Application No: DC/21/1628/HH

**Proposal**      **Householder planning application - ancillary, single storey accommodation**

**Location**      **Cages Farm, Tuffields Road, Whepstead, Bury St Edmunds, Suffolk, IP29 4TL**

Client	MR AND MRS J MARTYN	Scale: 1:100	BROWN & SCARLETT ARCHITECTS 1 Old Hall Barns, Thurston Road Pakenham, IP31 2NG Tel: 01284 768800 info@brownandscarlett.co.uk
Project:	PROPOSED STUDIO WORKSHOP CAGES FARM WHEPSTEAD	Date: JUNE 2021	
Drawing:	DETAILED PLANNING	Contract: 4477 Drg No. 02

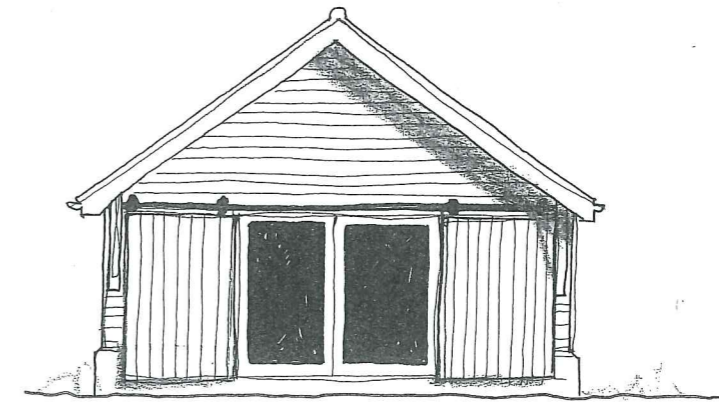
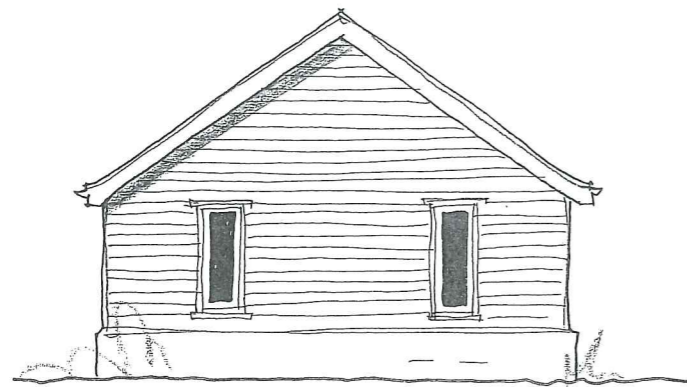
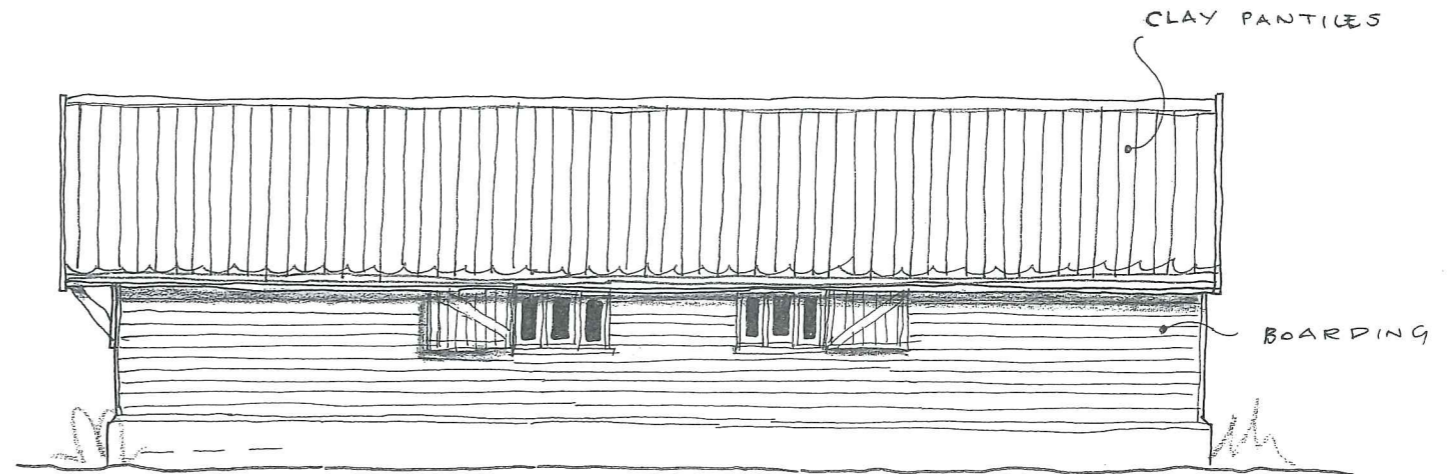
- 1 Your elevations and floor plans do not match. Your elevations show three roof lights on the east elevation, however there are only two shown on the floor plan, on opposite sides to each other (over dark room and WC). Your west elevation also shows two windows with shutters but only one is shown on the floor plan. Please amend accordingly.
- 2 A fee of £206.00 is required for this application. Please pay online by debit/credit card at <https://www.westsuffolk.gov.uk/doi/pay.cfm>. Please quote application no. DC/21/1628/HH and forward a copy of your receipt to [planning.technical@westsuffolk.gov.uk](mailto:planning.technical@westsuffolk.gov.uk)
